Date: 27 November 2015
Our ref: 170479
Your ref: 15/00455/DISC

Planning consultation: 15/00455/DISC Discharge of condition 16 (Item ii) of 10/00023/TWA.
Location: Oxford To Bicester Rail Link, Buckingham Road, Bicester, OX2 8HA.

Further information required

Figure 2: Topographic drainage pathways of the development site.

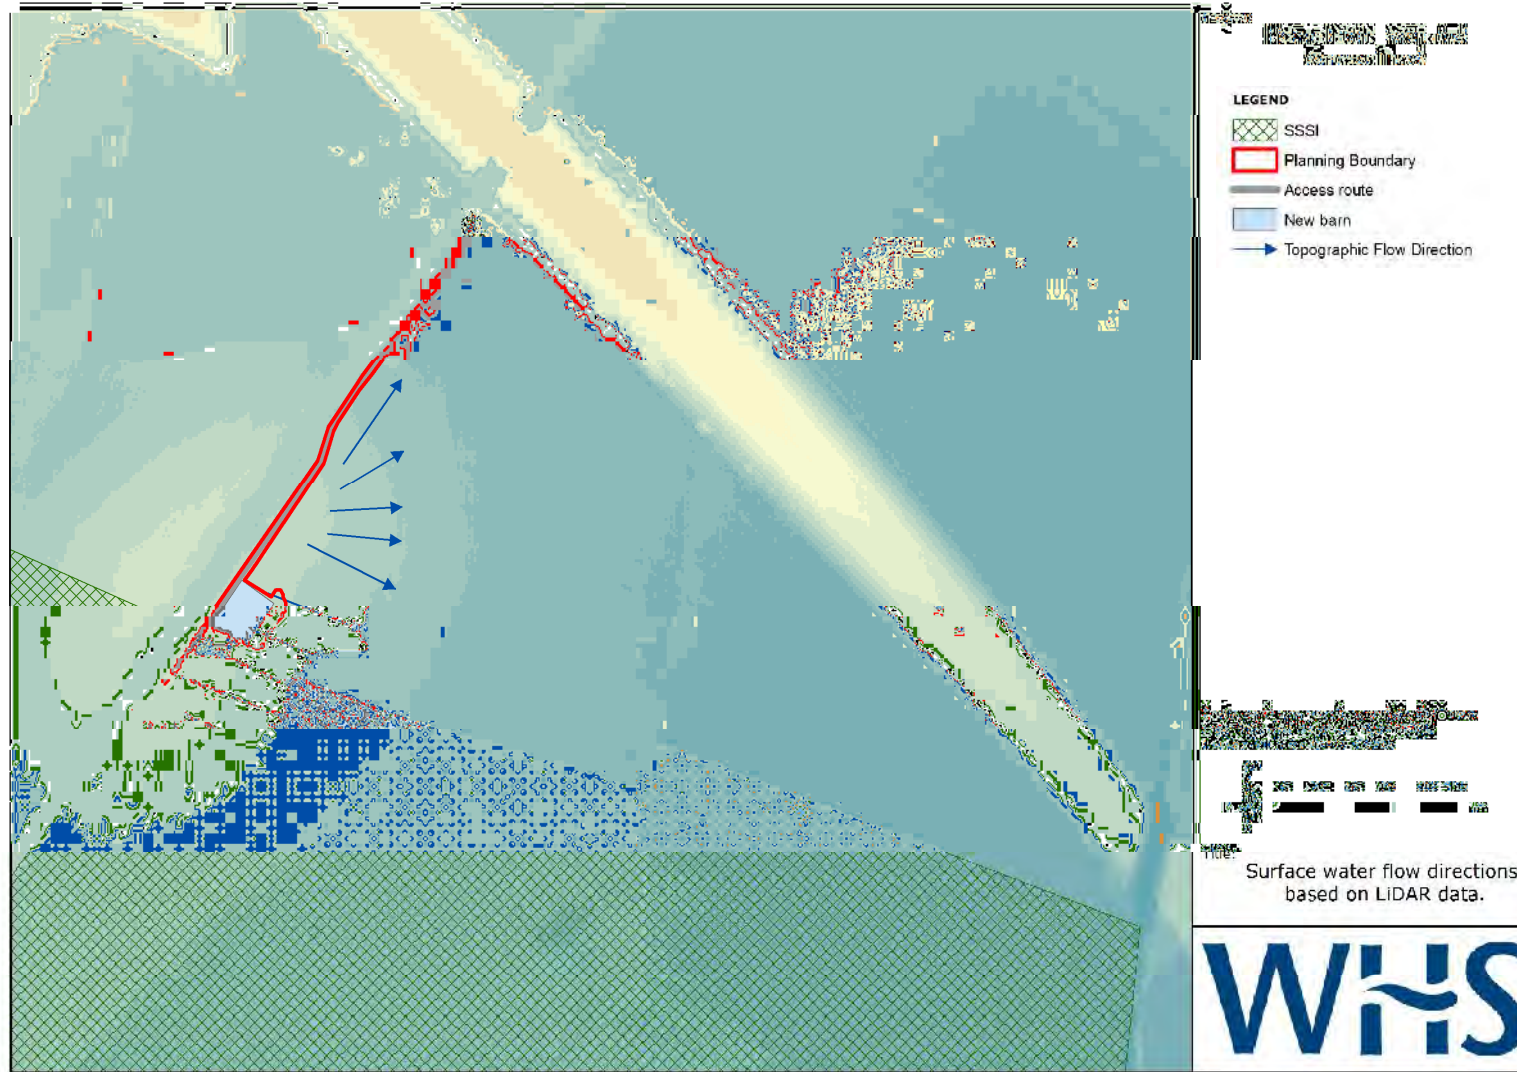
Figure 2 provided in the Wallingford Hydrosolutions Report, is not of sufficient detail to be able to definitively conclude that surface water runoff would not reach the SSSI, particularly as the proposed barn and access track are so close to the SSSI in this location. As groundwater flow is predicted to be dictated by surface topography, this is the same for groundwater flows.
